Application no: H16/1203/98

Description: Refurbishment works:
alterations and extensions

Location: White Hart Hotel
Market Place
Spalding
Lincs

TOWN AND COUNTRY PLANNING ACT 1990
NOTICE OF ACCEPTANCE OF AMENDMENT

6708/G/54.6 SCALE 1:50 NOV 98

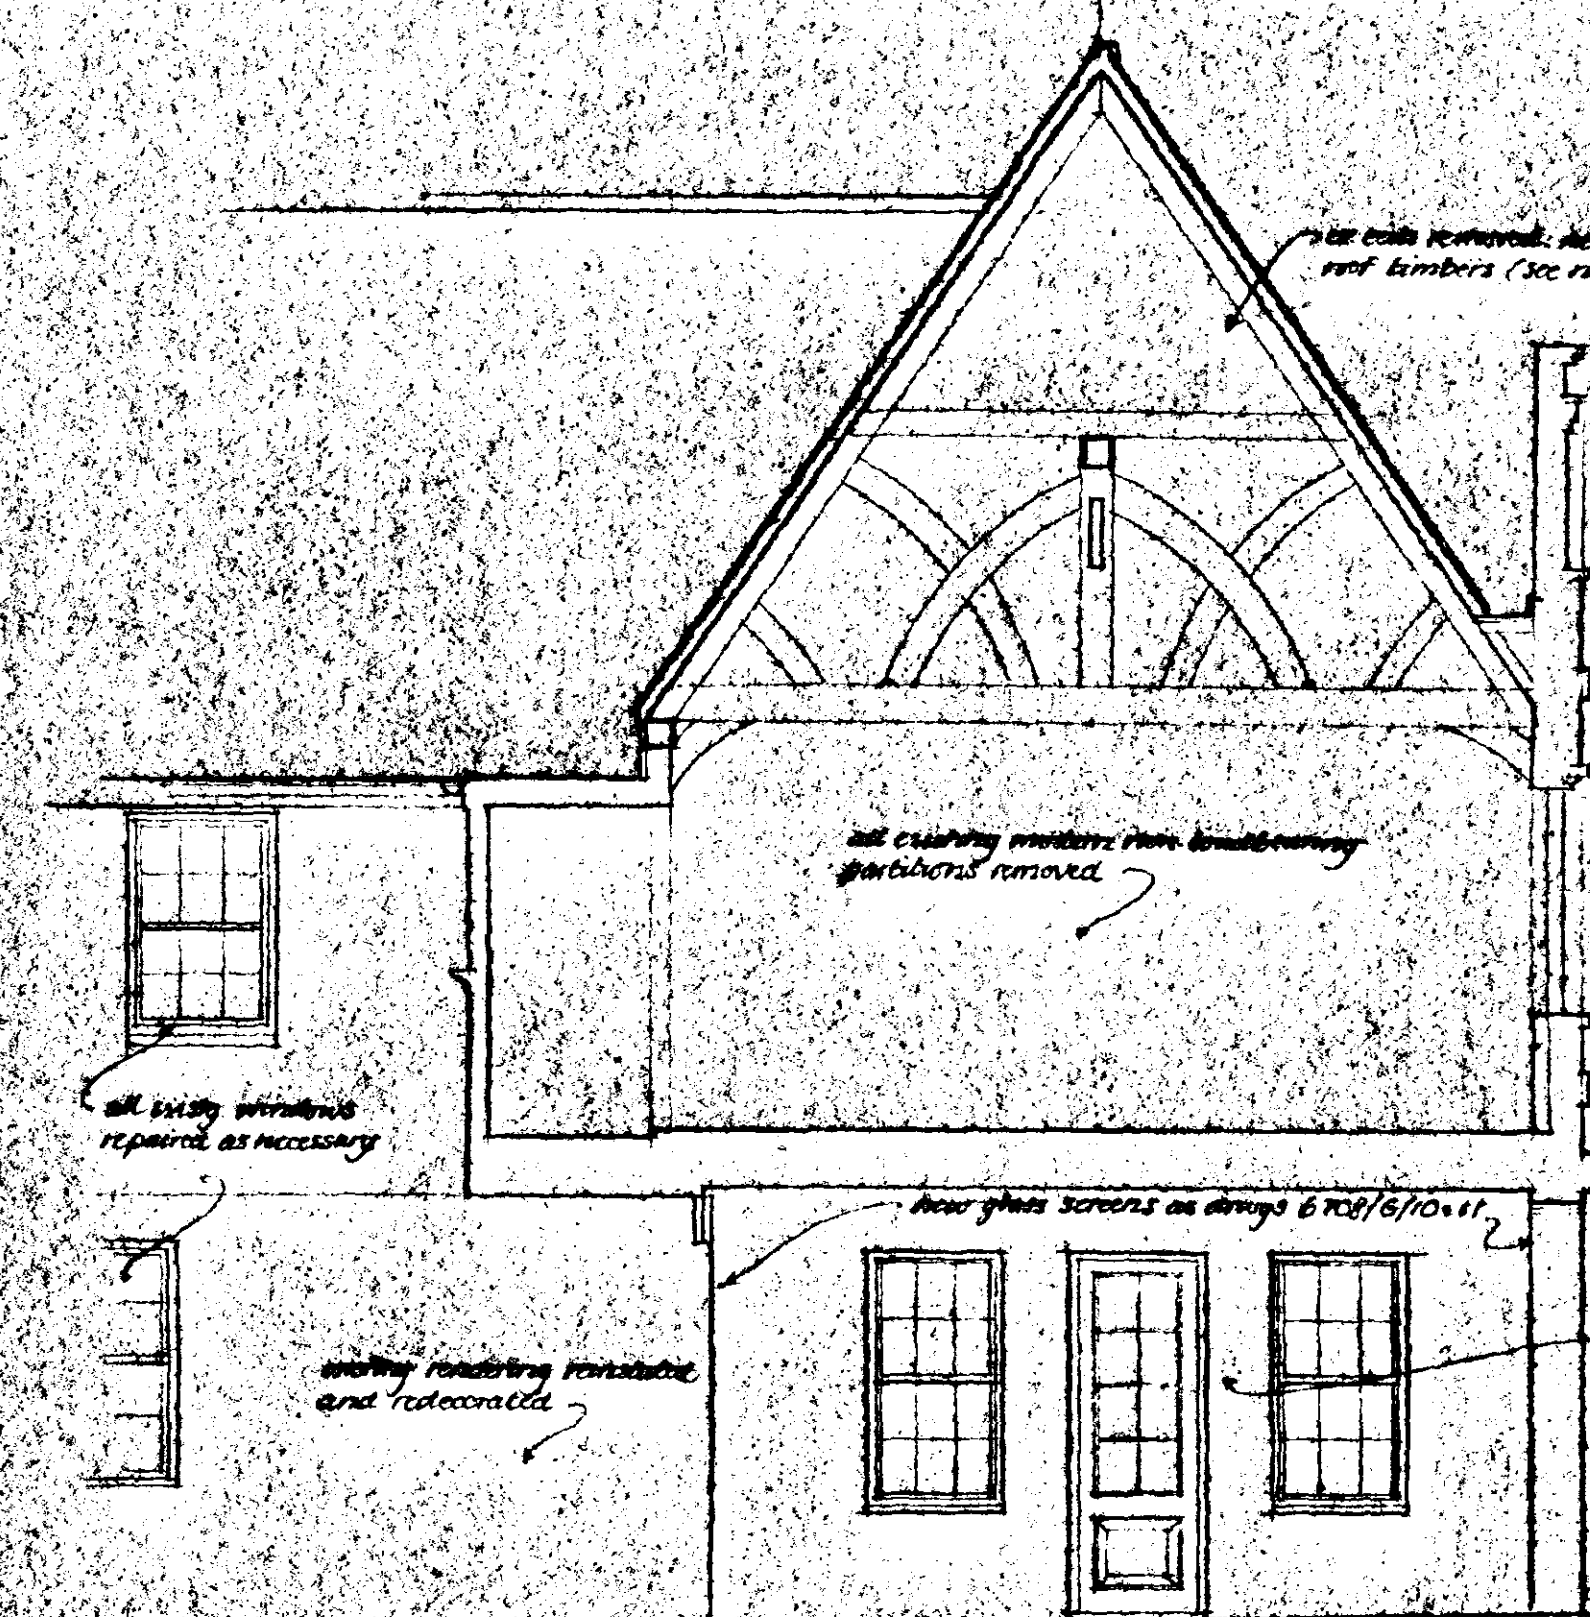
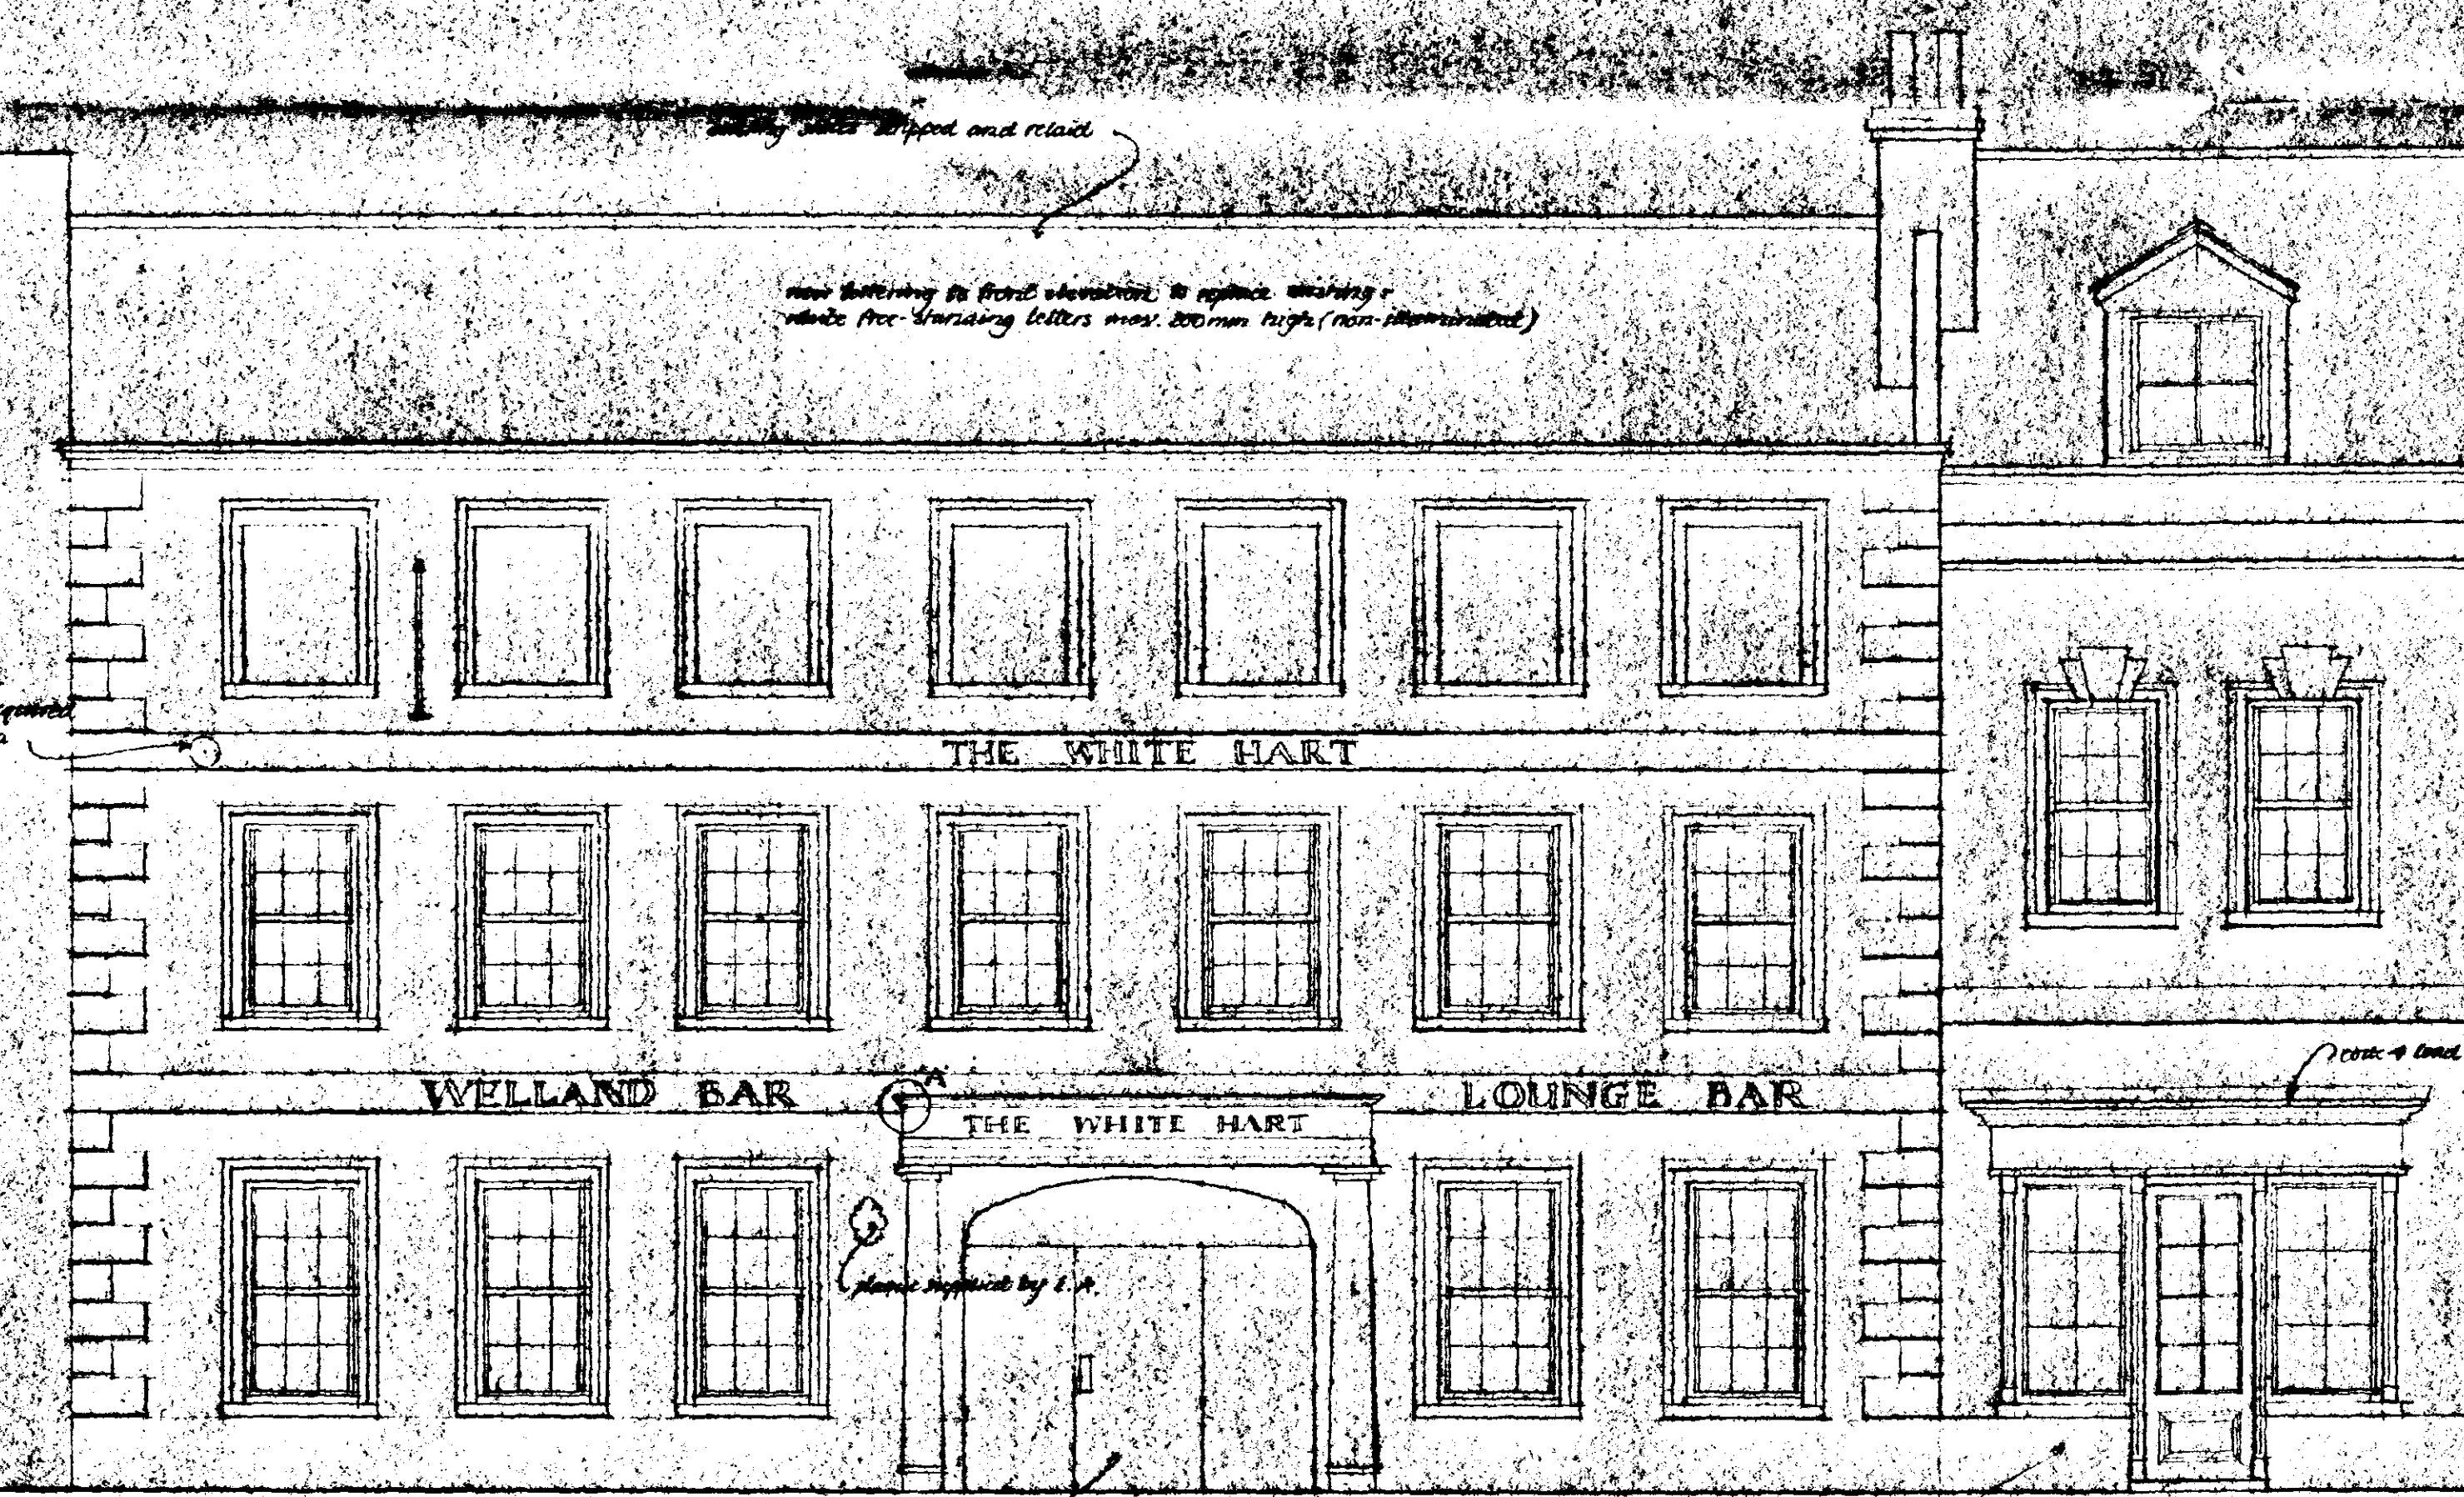
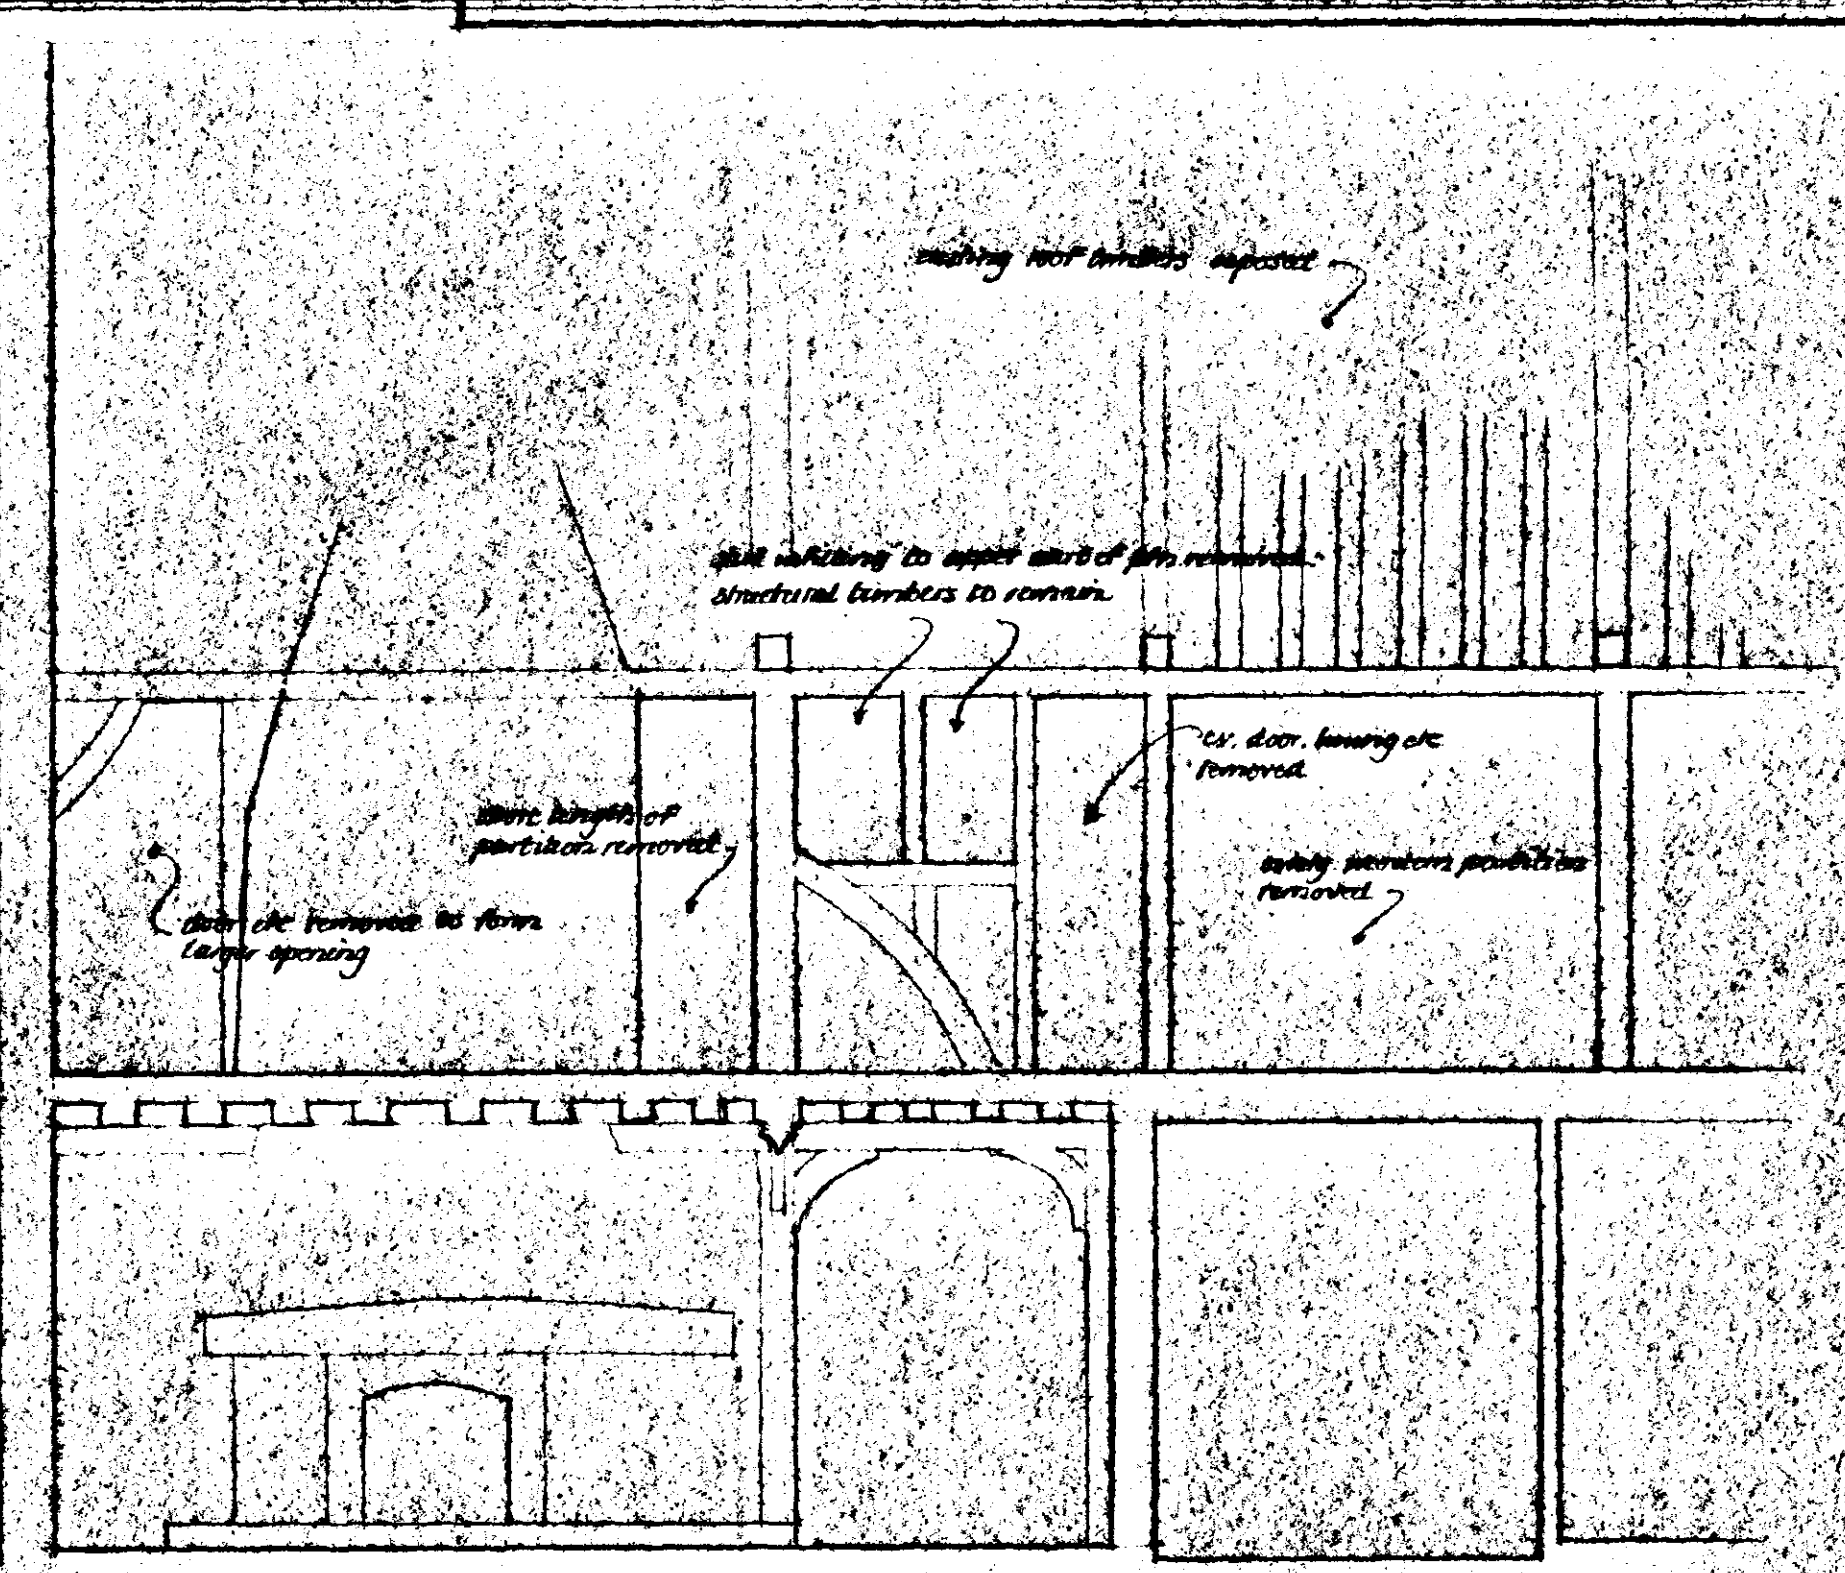
ALTERATIONS TO STAIRCASE INC. REUSE OF BALUSTRADES + BANNISTER ROIDS FOR ELSEWHERE IN THE PROPERTY.
ALTERATIONS TO DOORWAY TO ALLOW THE REUSE OF DOOR + FRAME FROM ELSEWHERE IN THE PROPERTY + TO PROVIDE FIRE ESCAPE FROM THE FIRST FLOOR.

Internal revision to staircase/Balustrades, re-use door & frame.
